Address: 52 Monument Street

perm. # 2013-02504

CHECK-LIST AGAINST ZONING ORDINANCE

Proposed Use/Work - change of use from single family to <sup>three</sup> two family - add two dormers on front part

TITLE
SITE PLAN

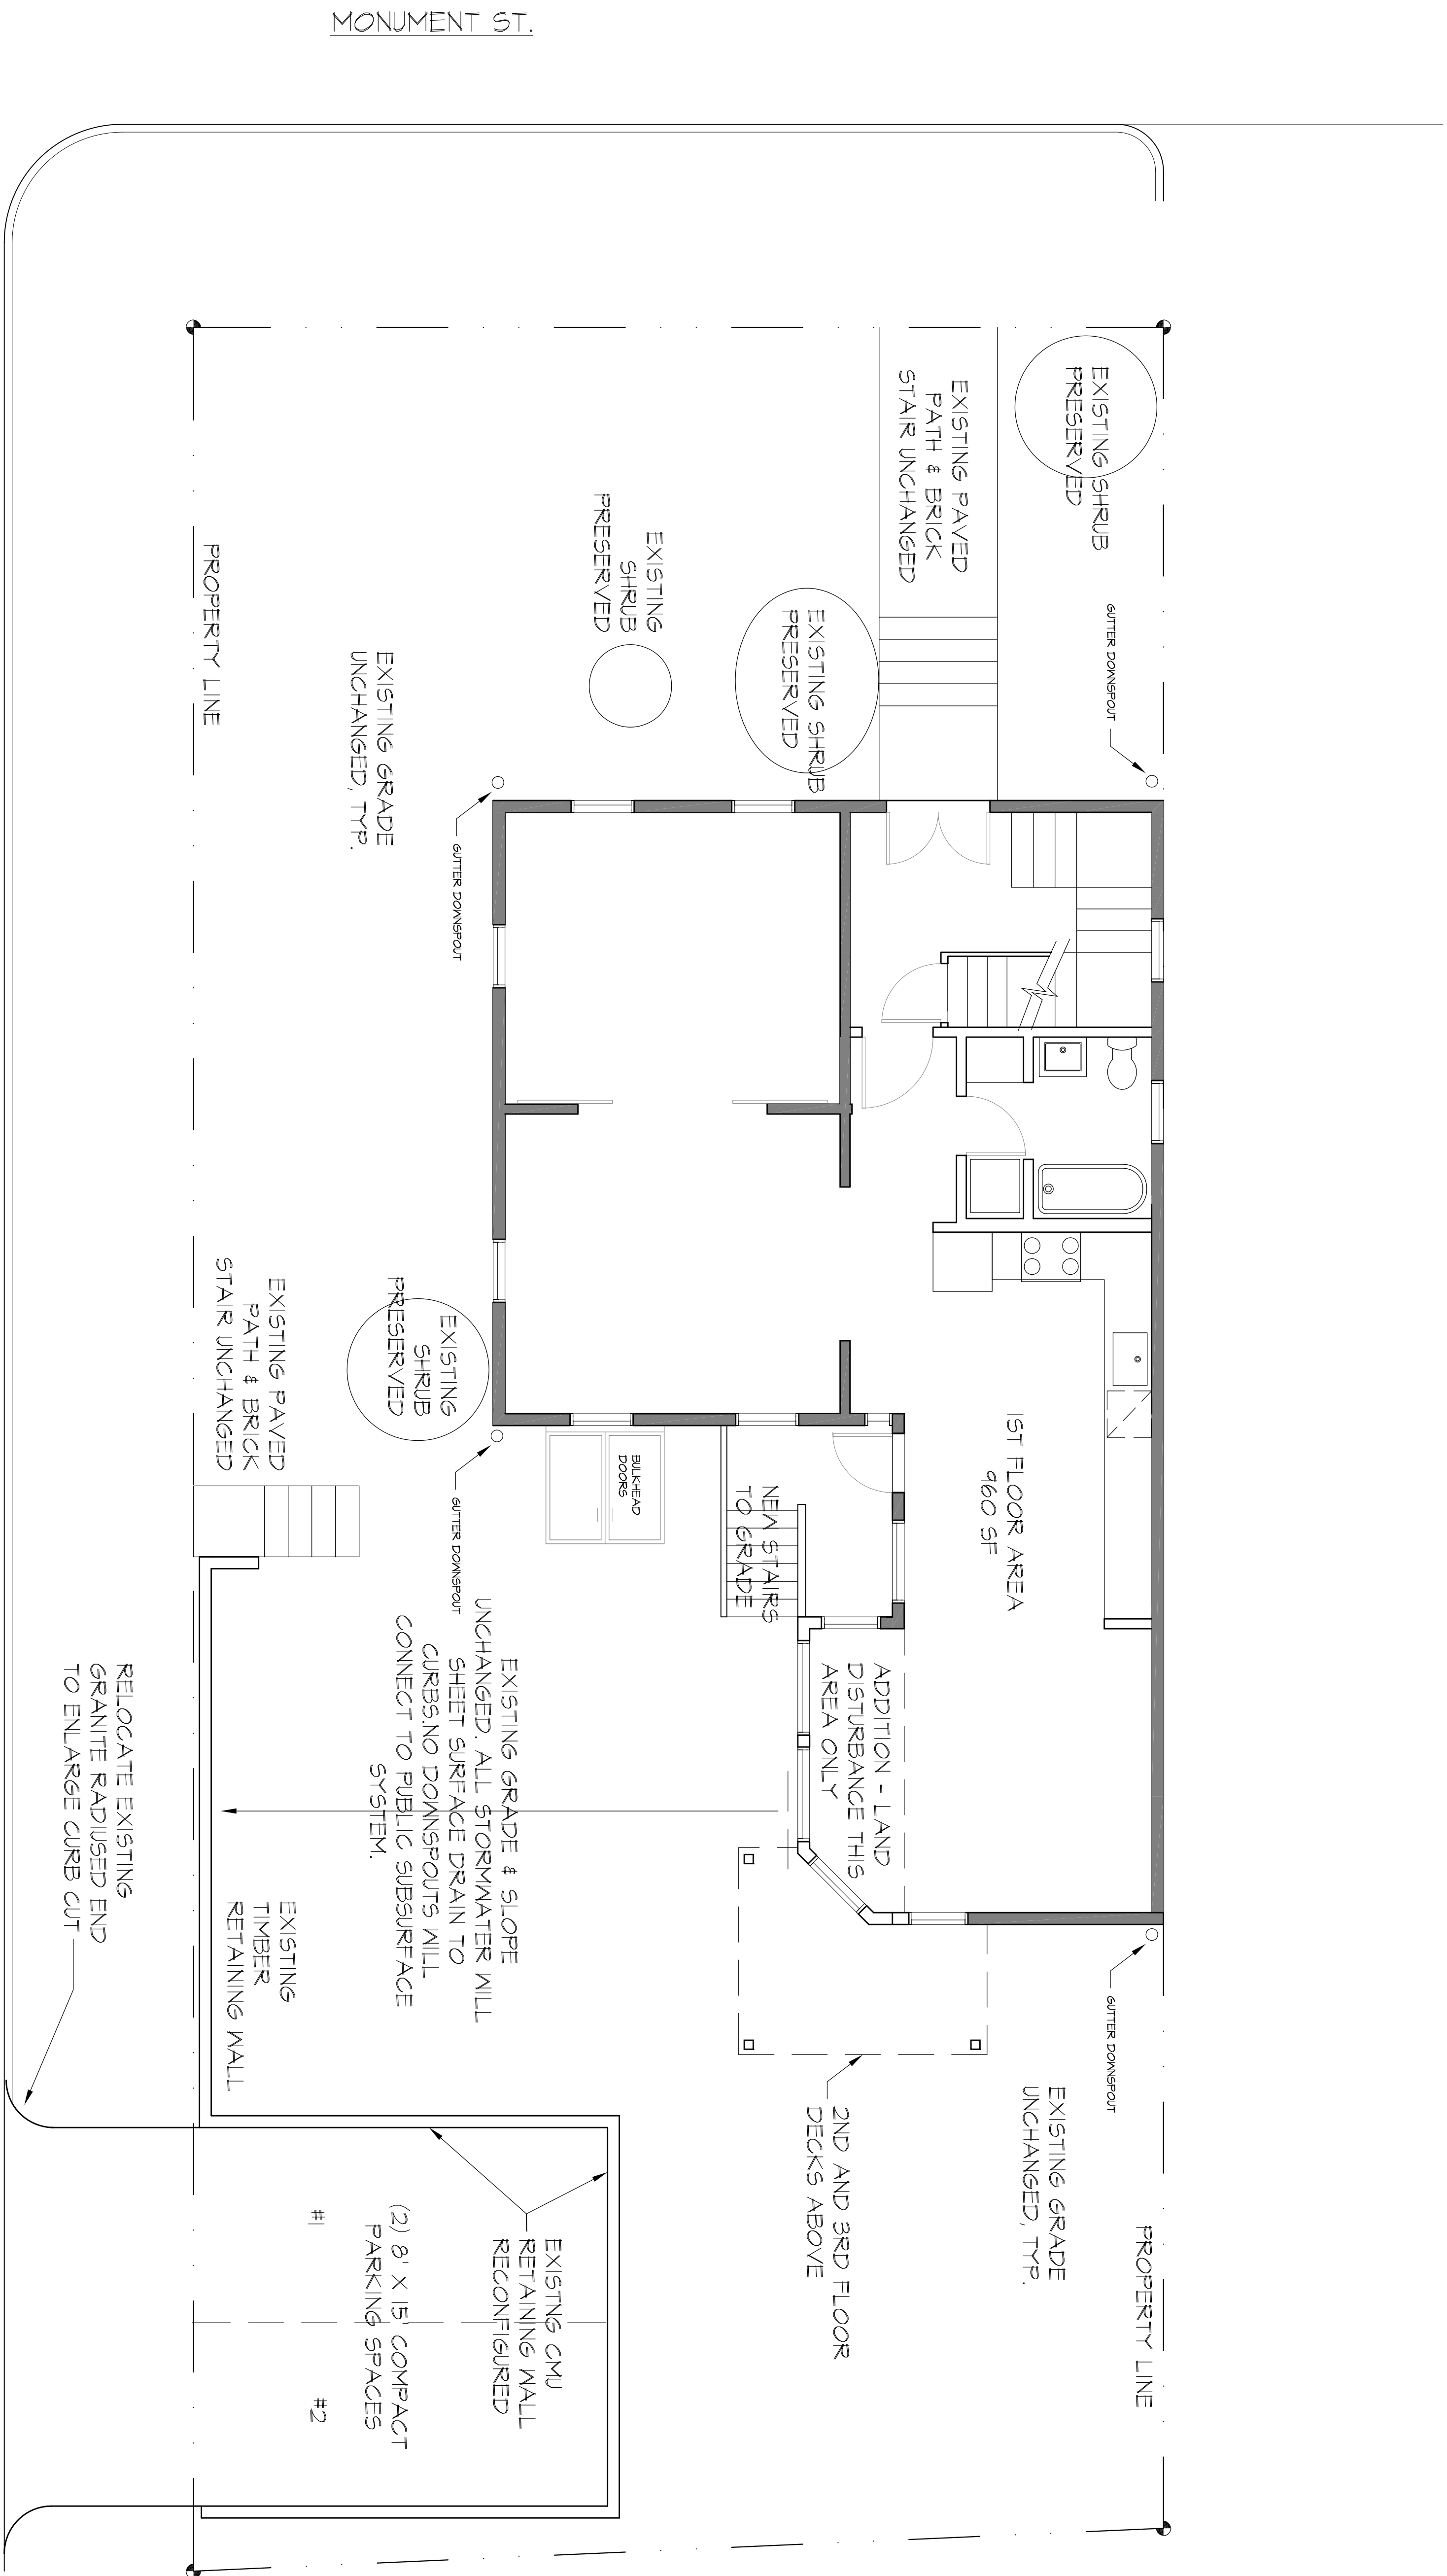
Lot Street Frontage - existing 40' min - 136.1 (OK)

Front Yard - 10' or average - <sup>24</sup> 10' to house - 10' to steps (OK) average - 0' - 62 monument - 6' to steps @ 4F <sup>Monuments</sup> - average 3' (OK)

Rear Yard - 20' min - 27' ~~min~~ 20' scaled to deck

\* Side Yard - 10' on left min - 10' given on boundary survey - deck is 7.25' scaled (OK) using section 14-433  
10' on right - side yard (rides street) - 12.5' scaled (OK)

Lot Coverage Impervious Surface - 55% = 1918  $\phi$  - 1144 w/ deck footprint (OK)  
open space 20% = 767.2832 <sup>+</sup> in front side of house (OK)

(2) using section 14-433 <sup>New deck</sup> for side setback for new deck <sup>2' setback</sup> side - can be reduced to 5' - 7' scaled (OK)  
rear - can be reduced to 5' - scaled @ just under 20'

SITE PLAN W/3 ONSITE PARKING

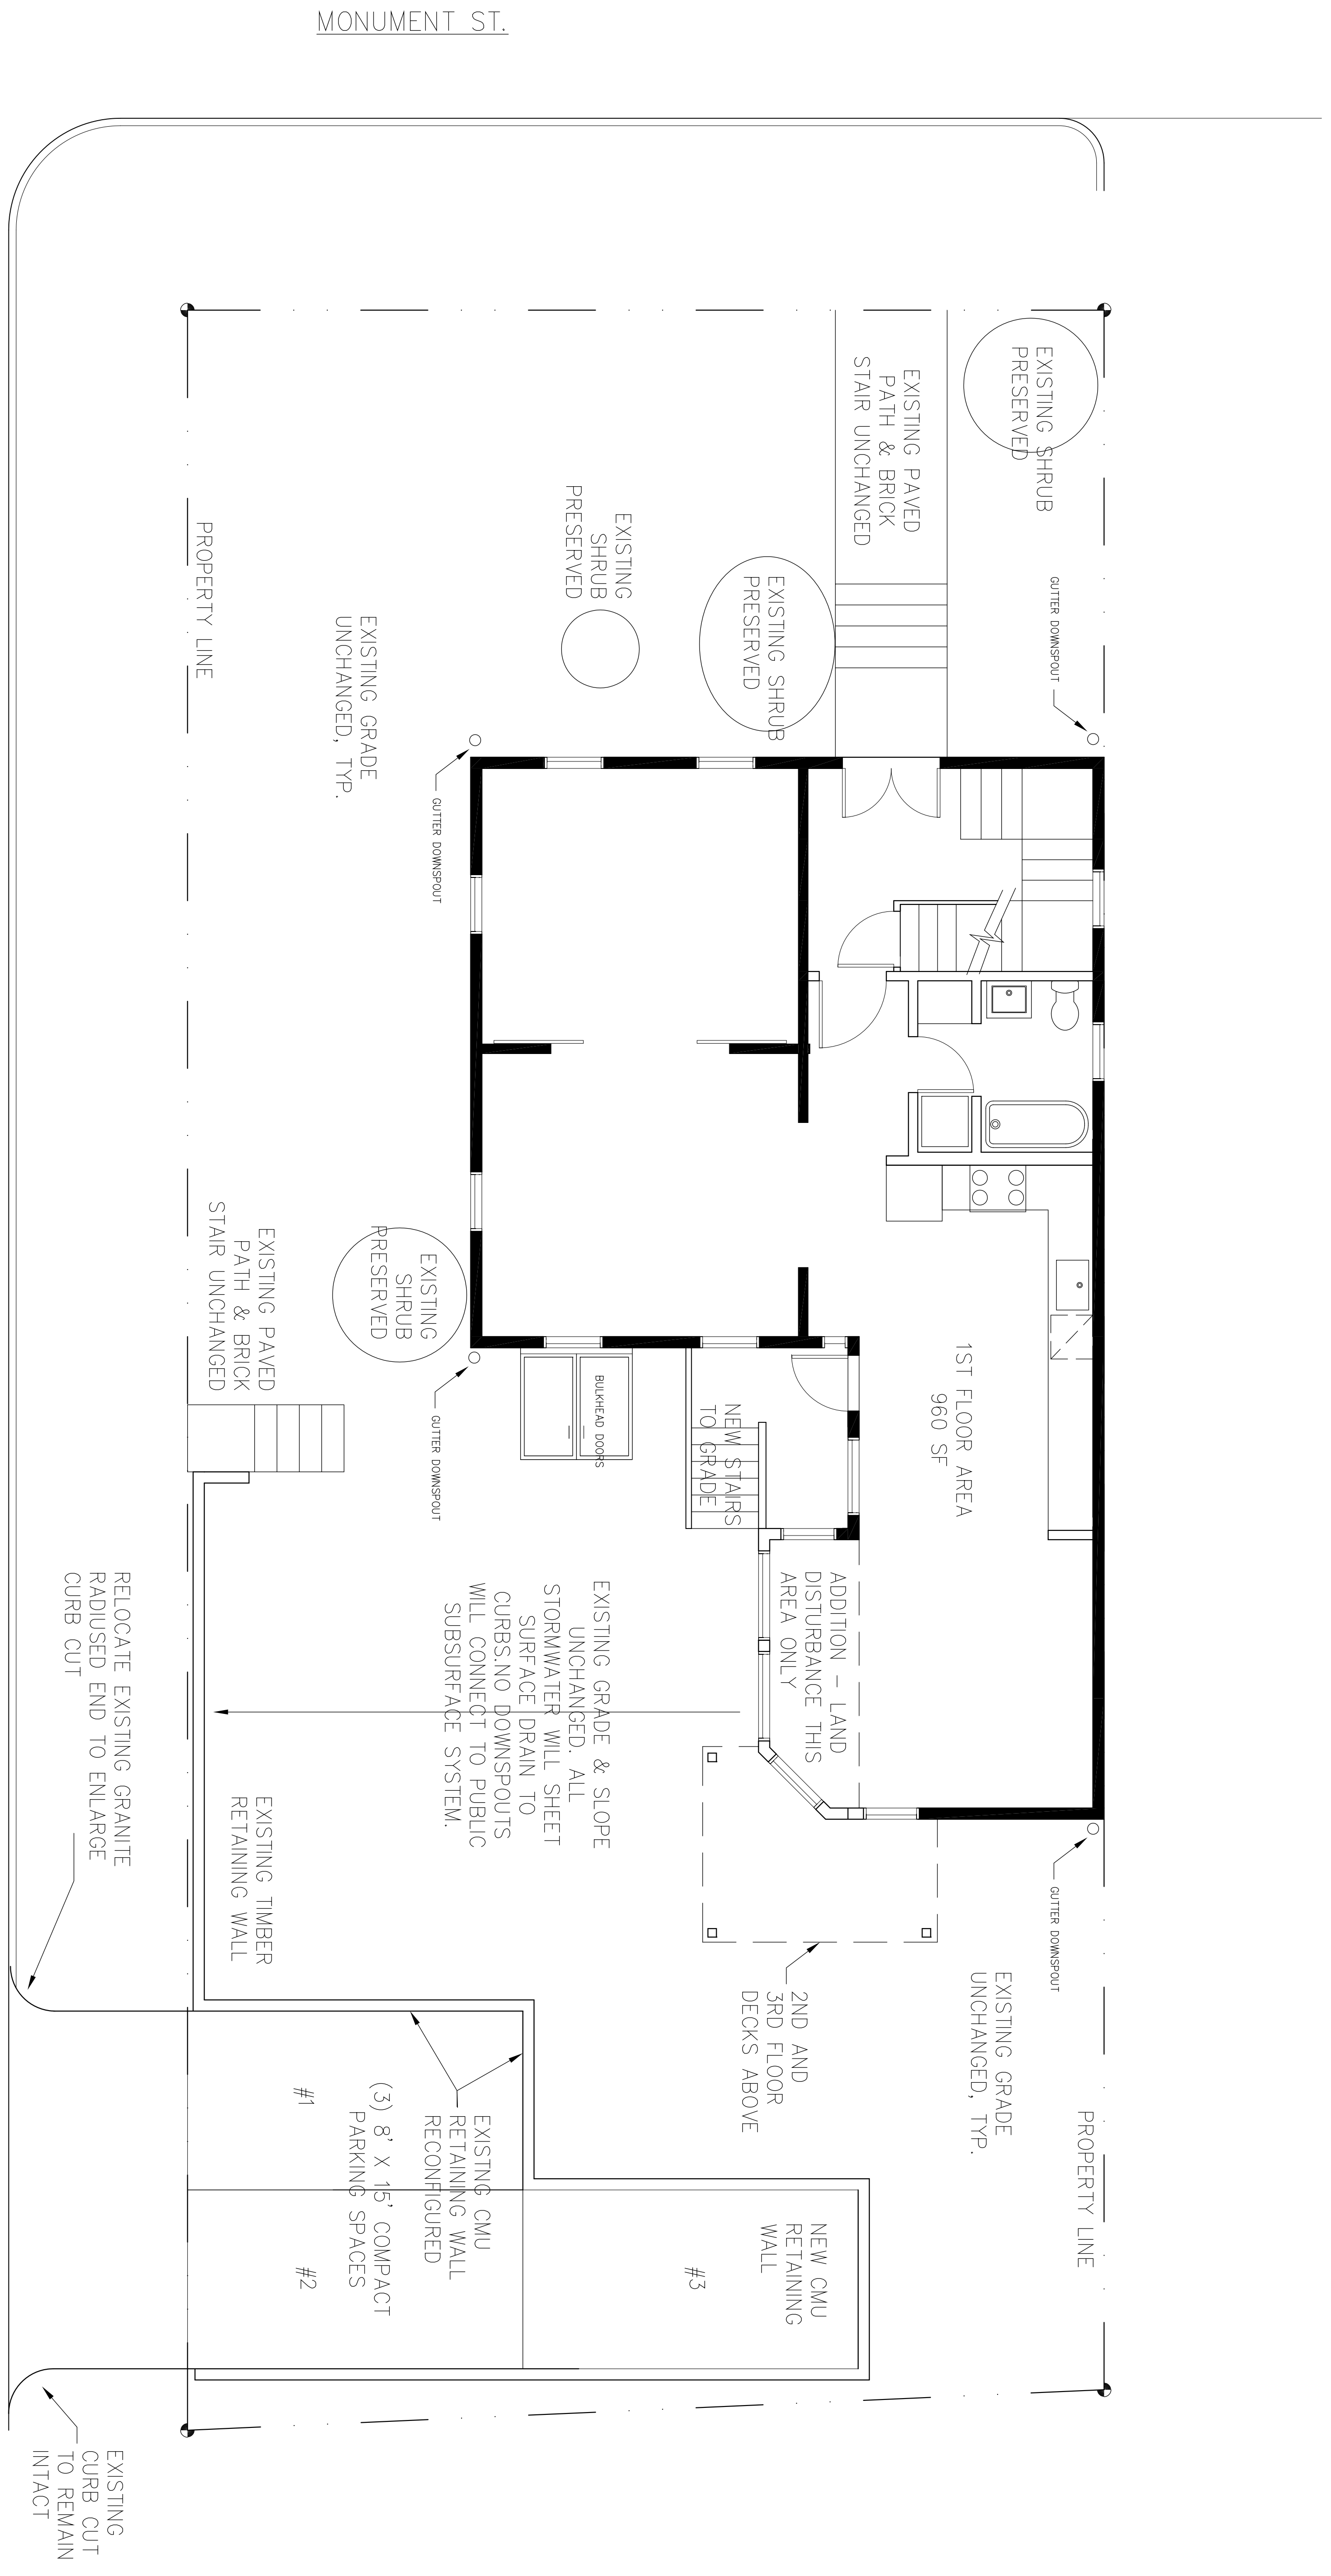
Off-street Parking - 3 spaces required - 3 shown - <sup>compact size</sup> approved by Tom Enos
